WEST SUSSEX COUNTY COUNCIL CONSULTATION

TO:	Arun District Council FAO: Anita Gardner
FROM:	WSCC - Highways Authority
DATE:	26 September 2019
LOCATION:	177 Middleton Road, Bognor Regis, PO22 6DF
SUBJECT:	M/62/19/PL Construct an additional dwelling house along Sundale Lane to rear of 177 Middleton Road.
DATE OF SITE VISIT:	n/a
RECOMMENDATION:	Advice
S106 CONTRIBUTION TOTAL:	n/a

Drawing Title
Block Plan and Site Plan

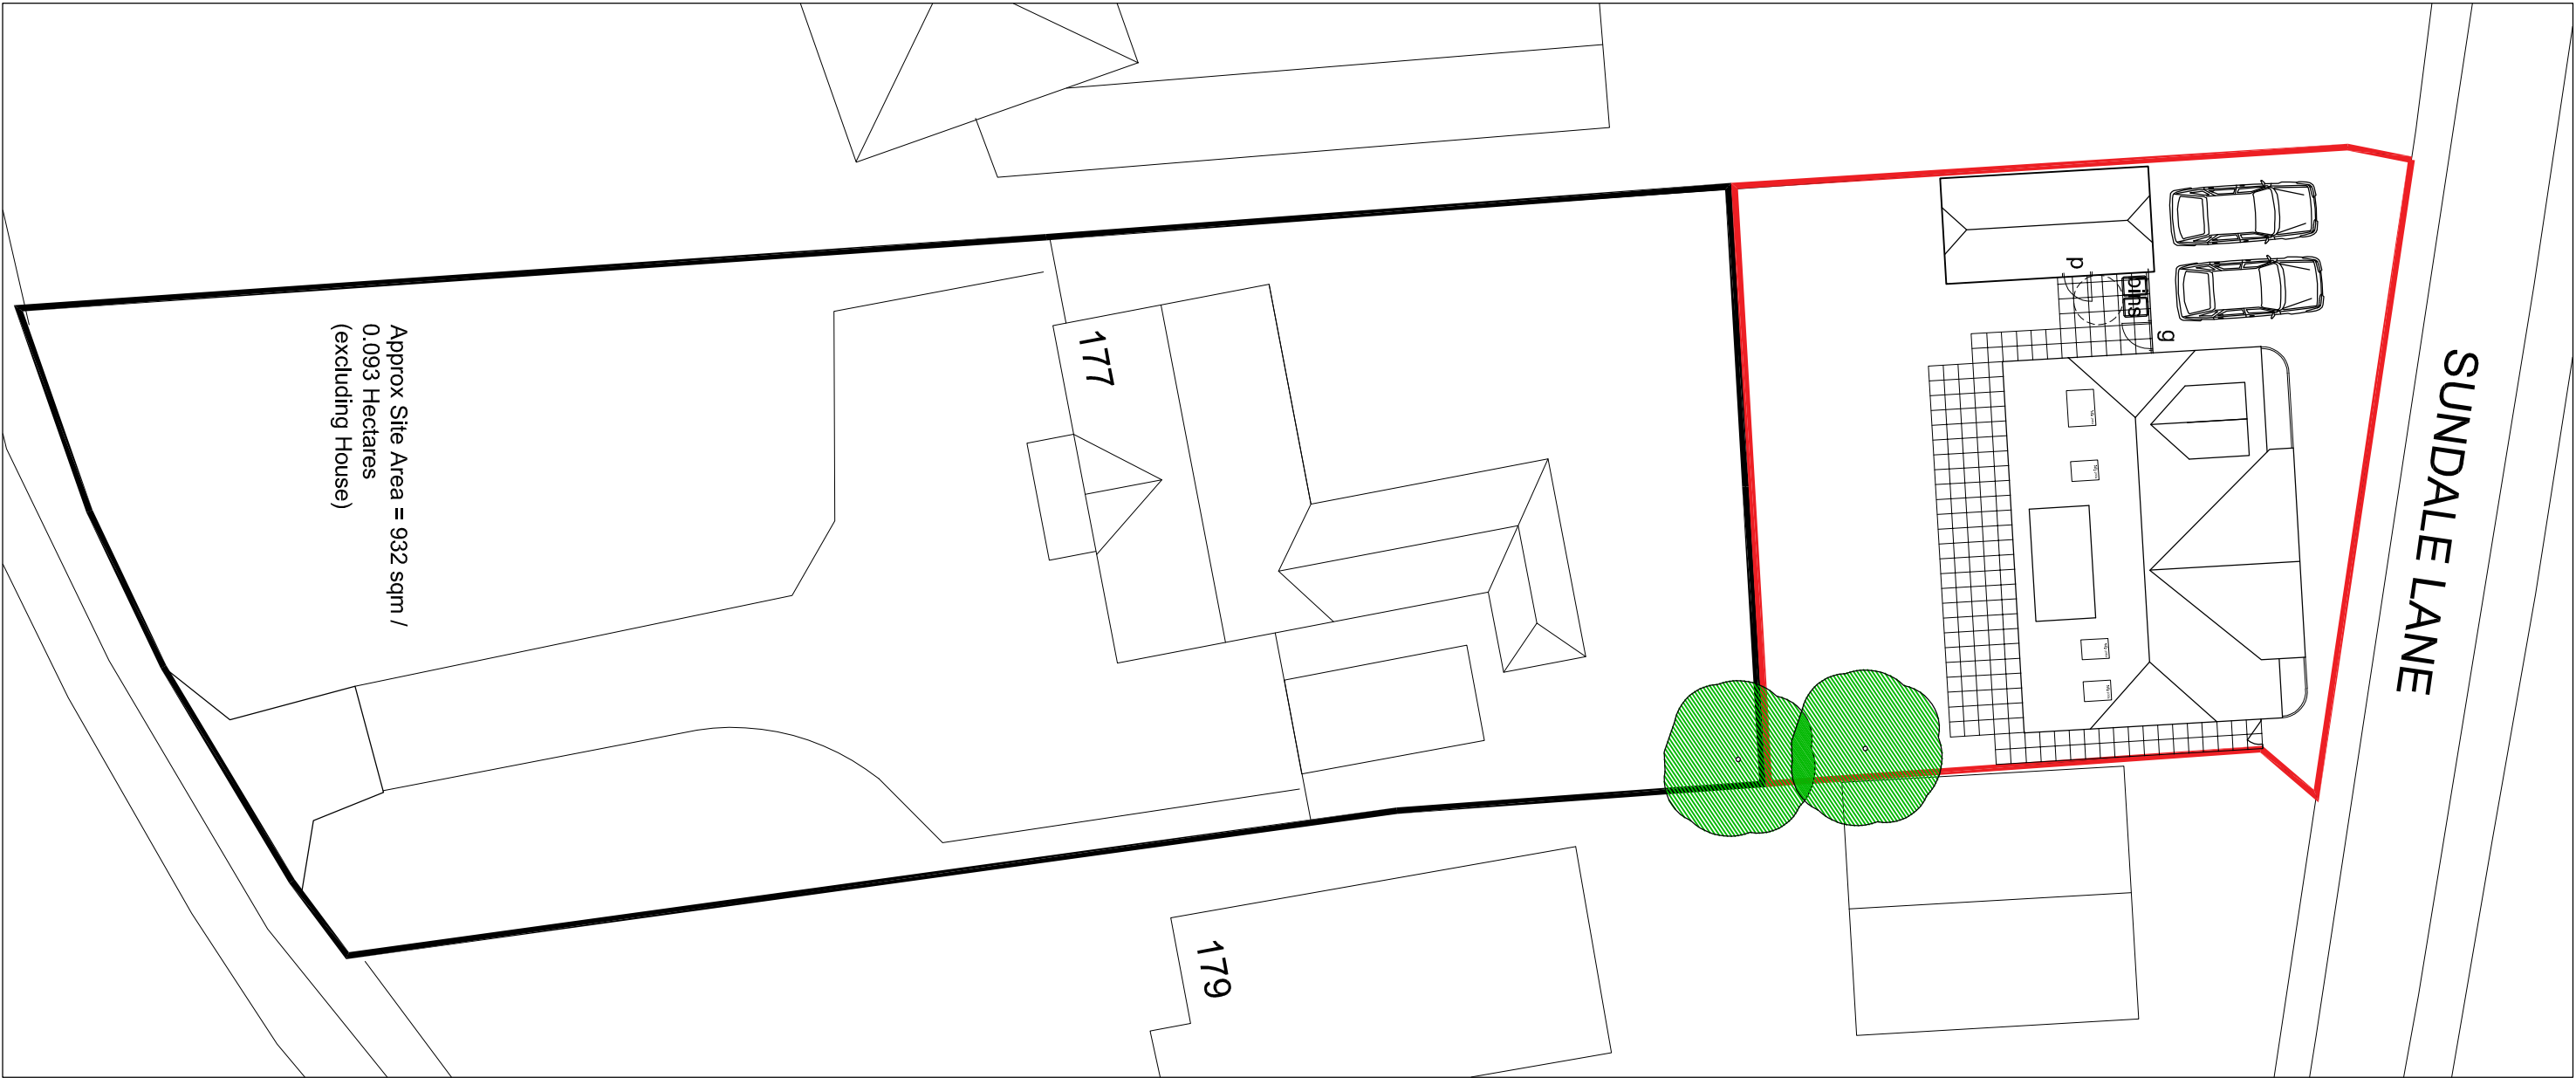
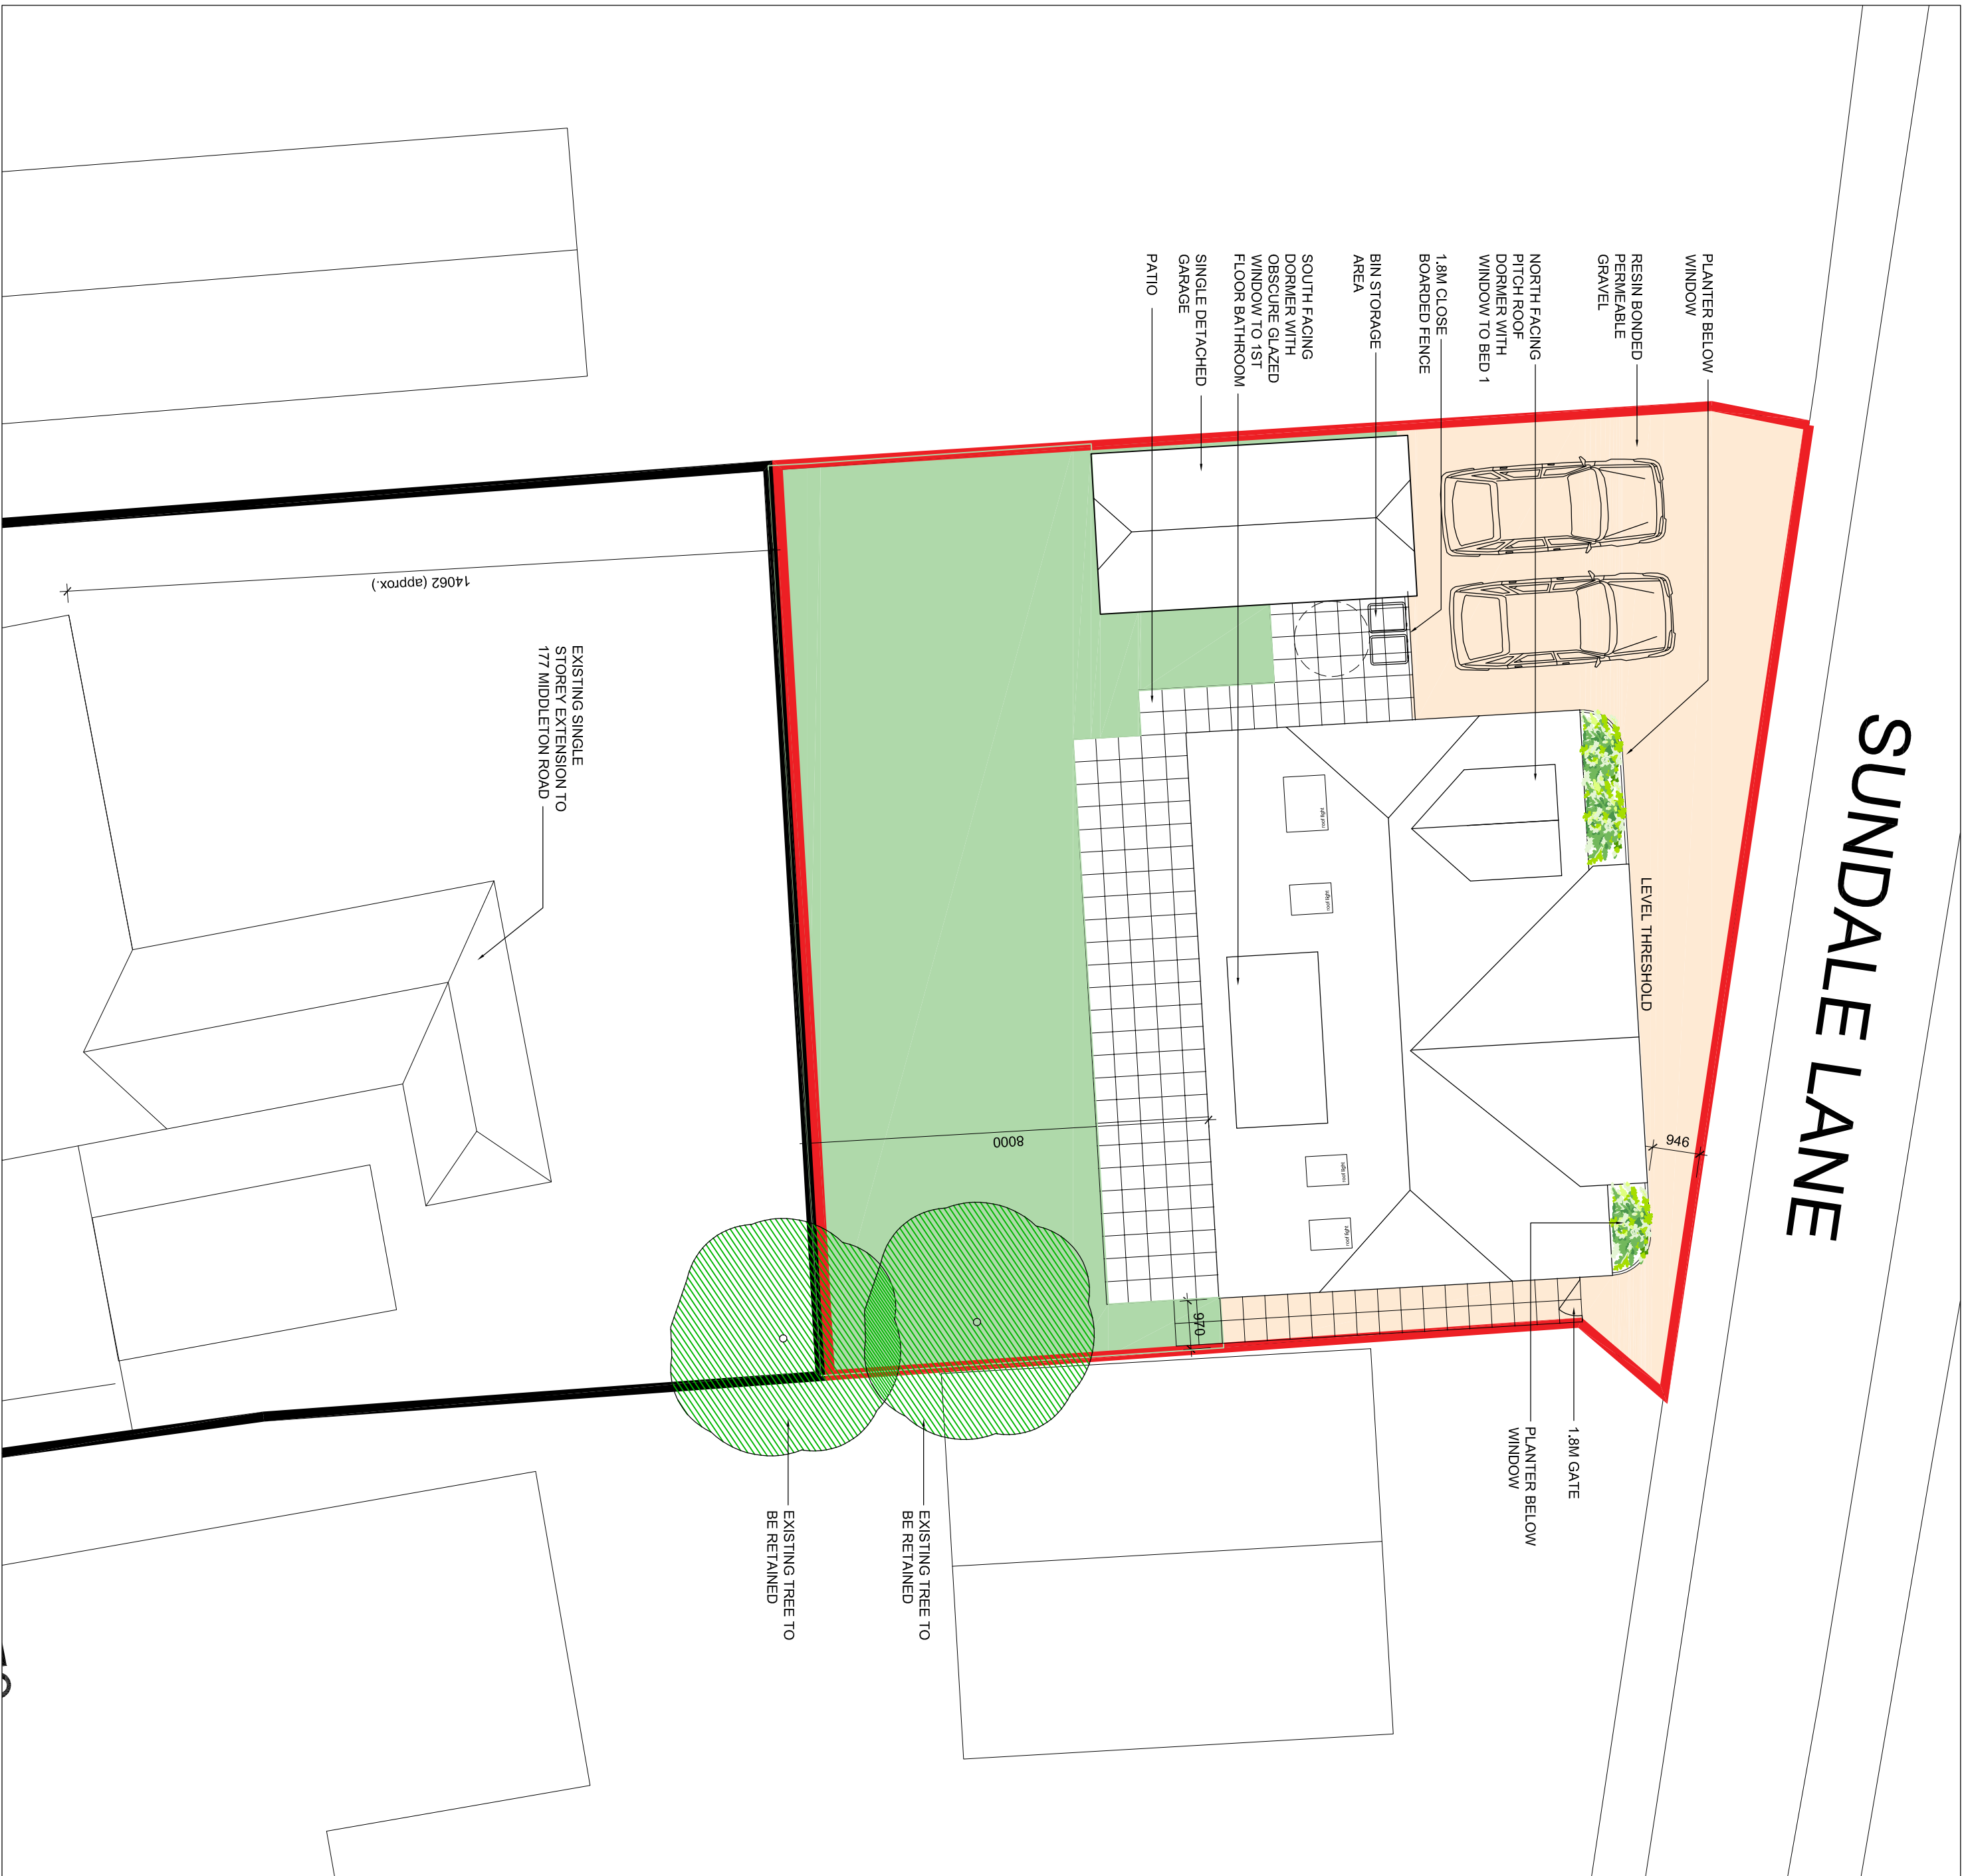
The proposed plans indicate that three parking spaces will be provided on site, including one space within the proposed single garage. The WSCC parking demand calculator expects that this is a sufficient parking provision for a dwelling of this size and location. The proposed plans indicate that each external parking space meets minimum dimensions of 2.4 x 4.8m as set out in Manual for Streets (MfS). An internal floor plan of the proposed garage has not been provided, the applicant is advised that in order for the garage to count as parking provision, the internal dimensions of the garage should meet minimum specifications of 3 x 6m as set out in MfS. A turn on site would be preferred although this is not considered to result in a highway safety concern as it is expected that vehicles will exit onto the publicly maintained highway in a forward gear.

The site is sustainably located within walking distance of local shops and services, primary school, doctors surgery and bus stops providing access into Bognor Regis and further afield. Cycling is a viable option within the vicinity and details of secure and covered cycle storage can be secured via condition. The applicant should be aware that cycle storage may be accommodated within the garage providing it is demonstrated that the garage meets the minimum internal MfS specifications set out above.

No part of the development shall be first occupied until the car parking has been constructed in accordance with the approved site plan. These spaces shall thereafter be retained at all times for their designated purpose.
